The Sizewell C Project

**Natural England's Comments on the Permanent and Temporary Beach
Landing Facility and SSSI Crossing Plans**

Planning Inspectorate Reference: EN010012

24th September 2021

DRAWING NO:
SZC-SZ0100-XX-000-DRW-100205

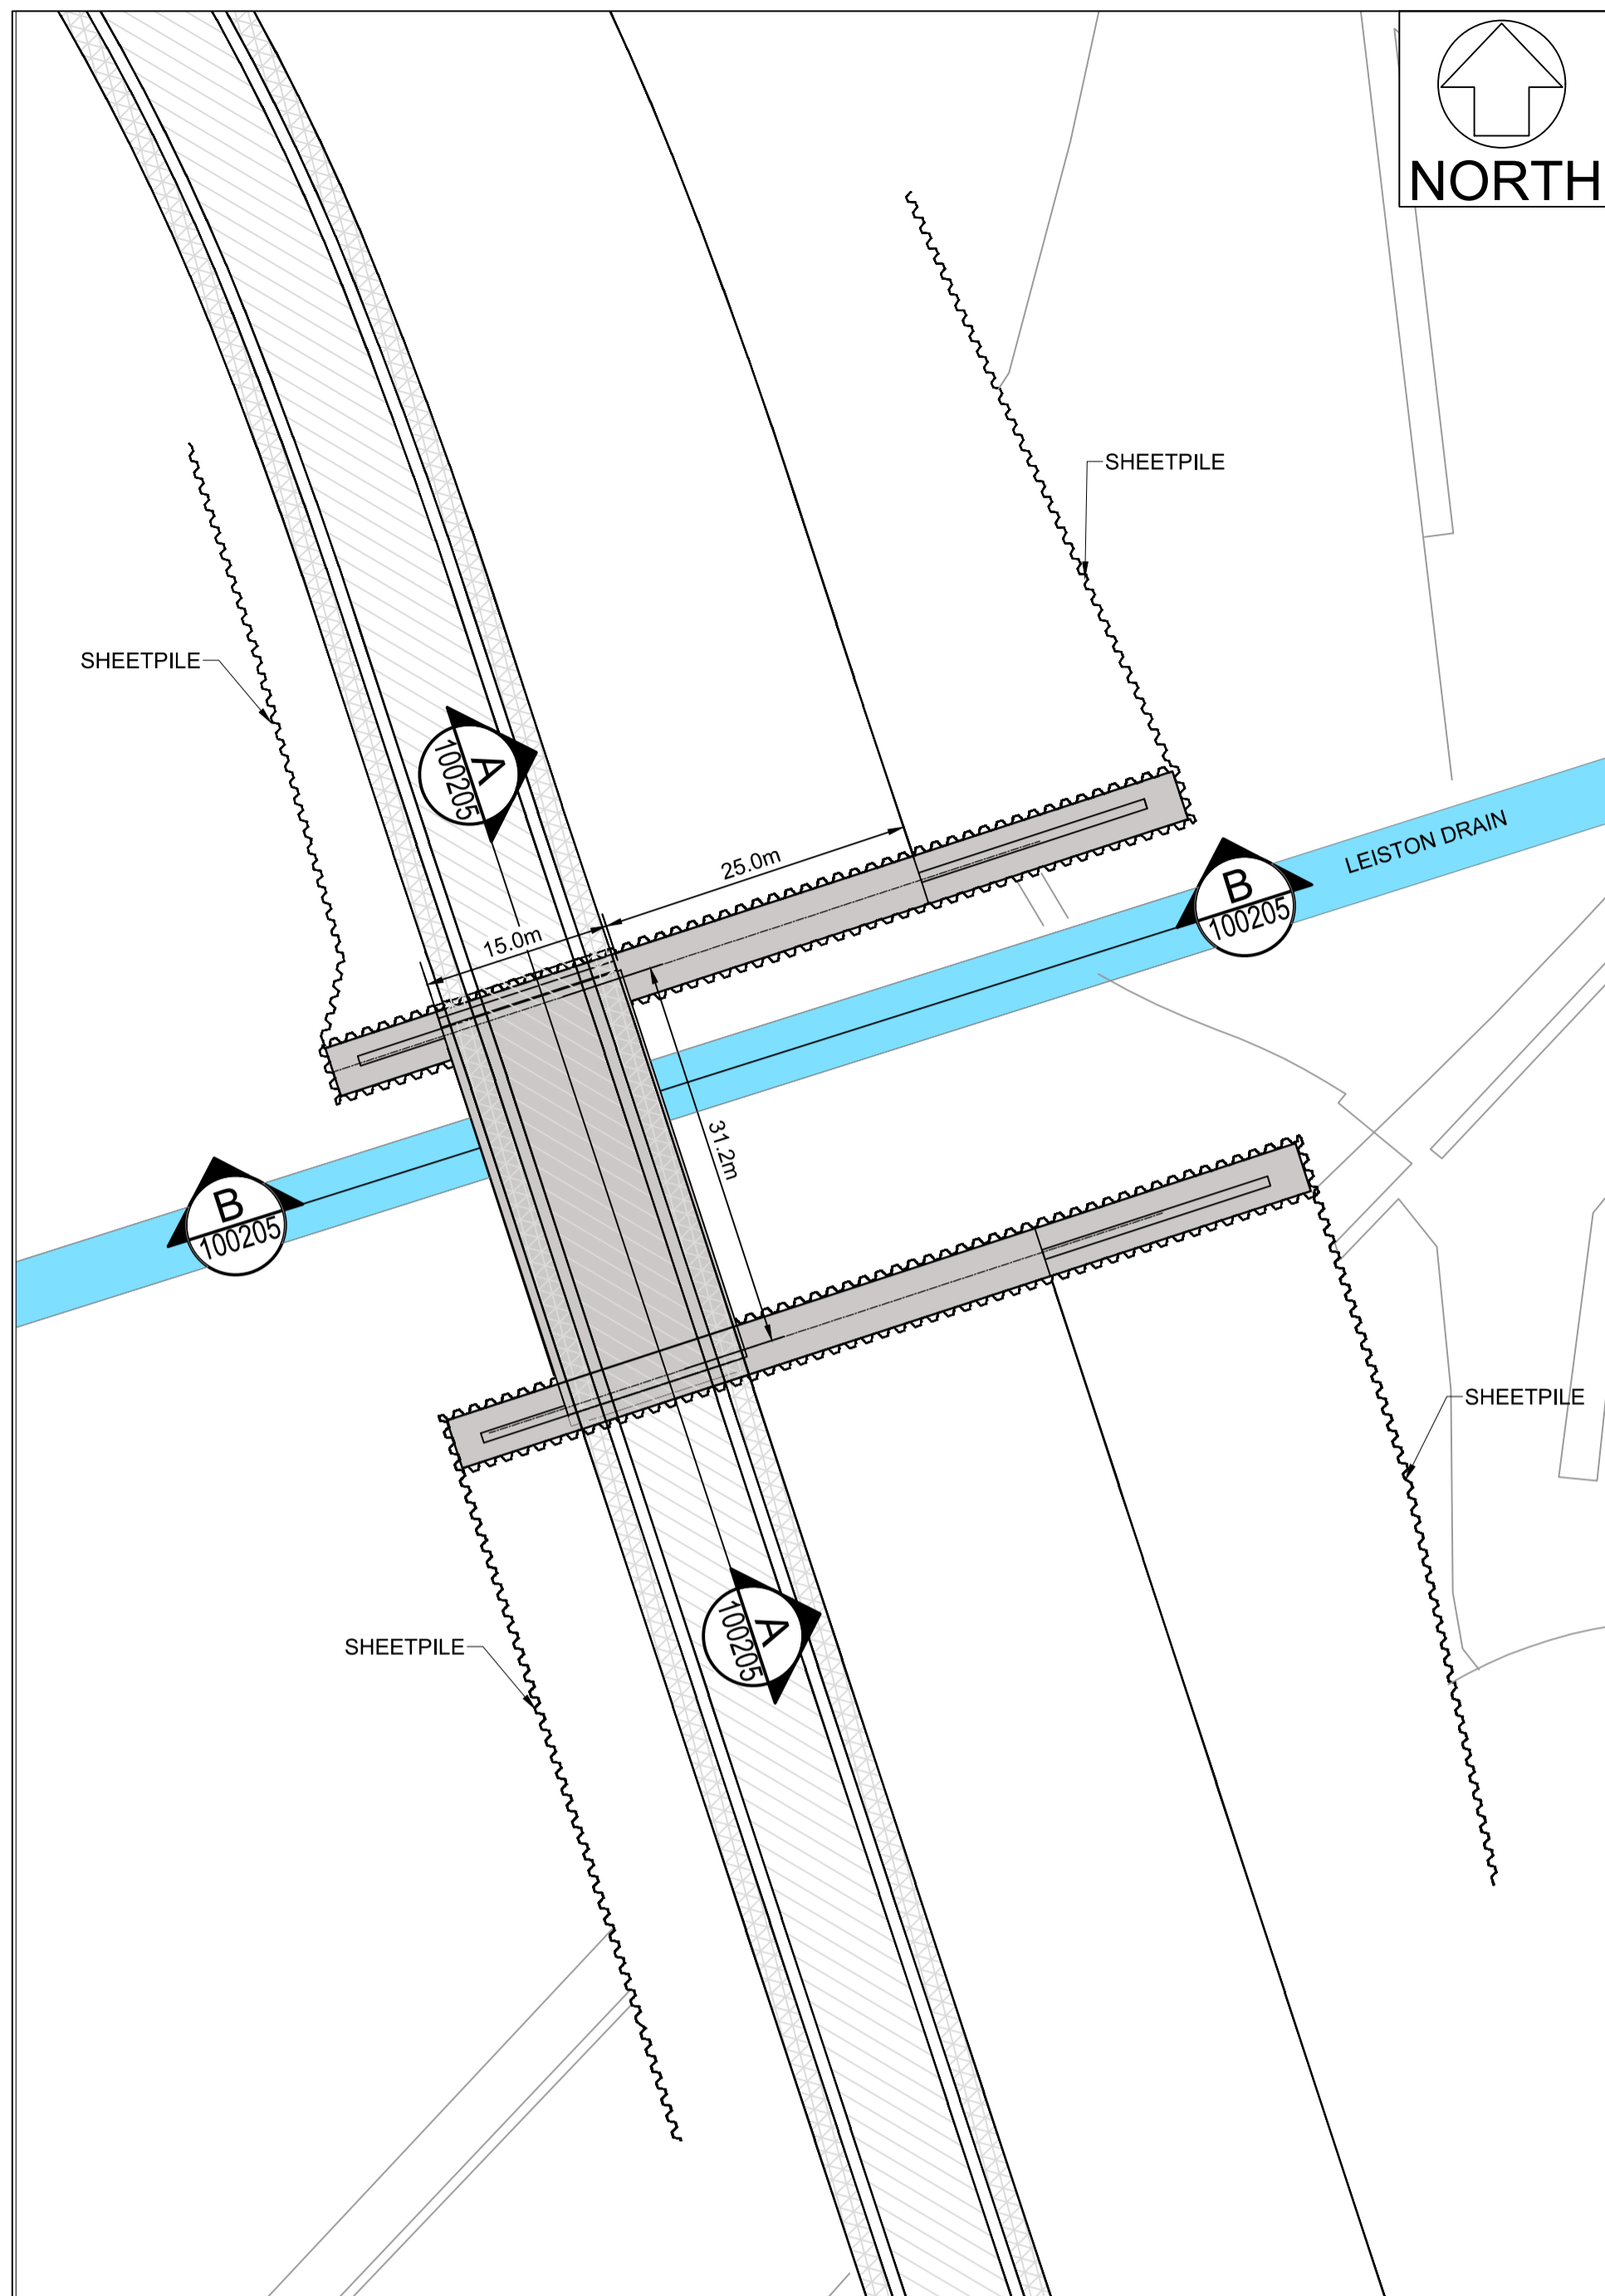
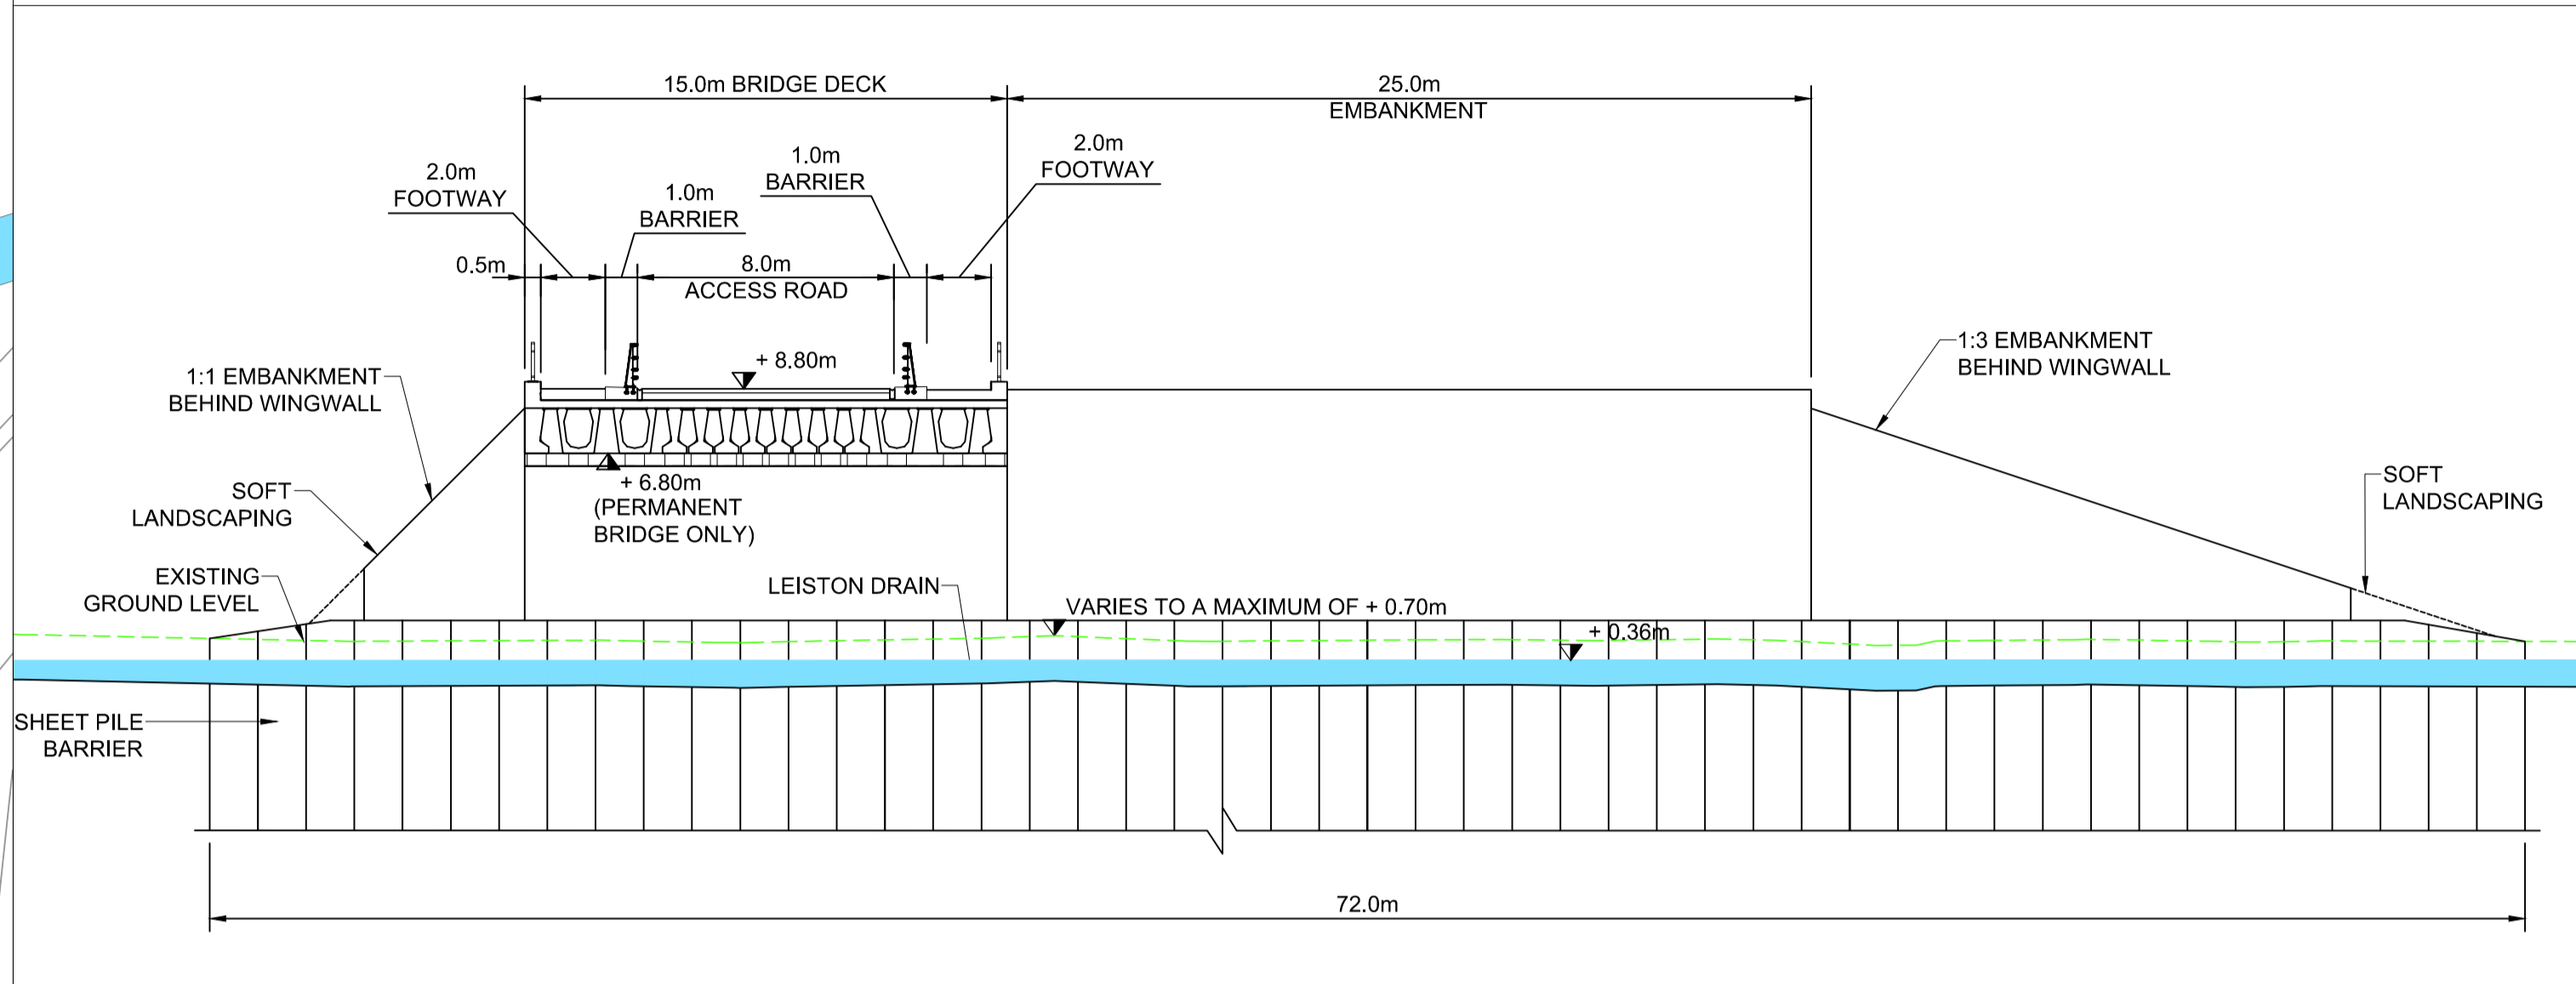
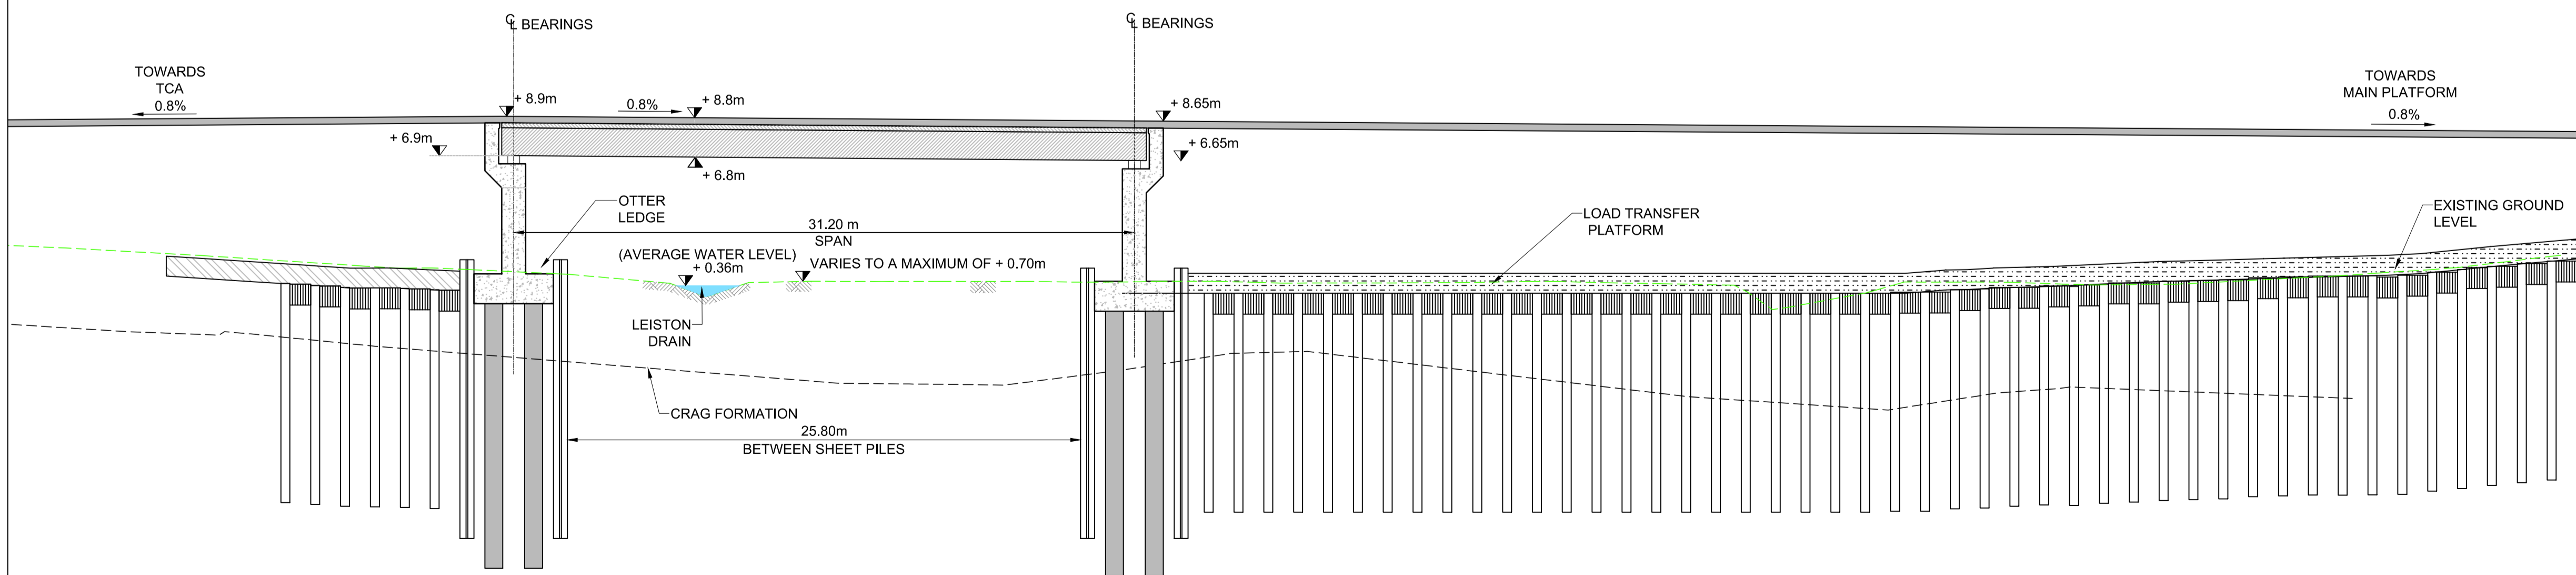
- 1.2 We welcome the continued optimisation of the SSSI crossing design which features a hybrid culvert and free-span bridge. Natural England acknowledges that the Applicant has taken steps to improve the SSSI crossings design to raise soffit height and reduce width post-construction to improve dispersal of invertebrates.

- 1.3 We understand that the preference for this design option by the applicant is based on the construction timetable (a three-span bridge would potentially take longer to build). We believe that the current iteration of the hybrid culvert and free-span bridge design is as optimal as possible within the limits of this design option. Should the examining authority consider this reasoning justifiable we believe that the current hybrid culvert and free-span bridge design represents a best alternative.

- 1.4 This issue will remain as an amber risk rating within our statement of common ground as our advice remains that made within our Relevant [RR-0878] and Written Representations [REP2-153]. We reiterate these comments that our preference remains for a three-span bridge which would provide the least land take and have a smaller impact of invertebrate communities and ultimately have the least impact ecologically on Sizewell Marshes SSSI.
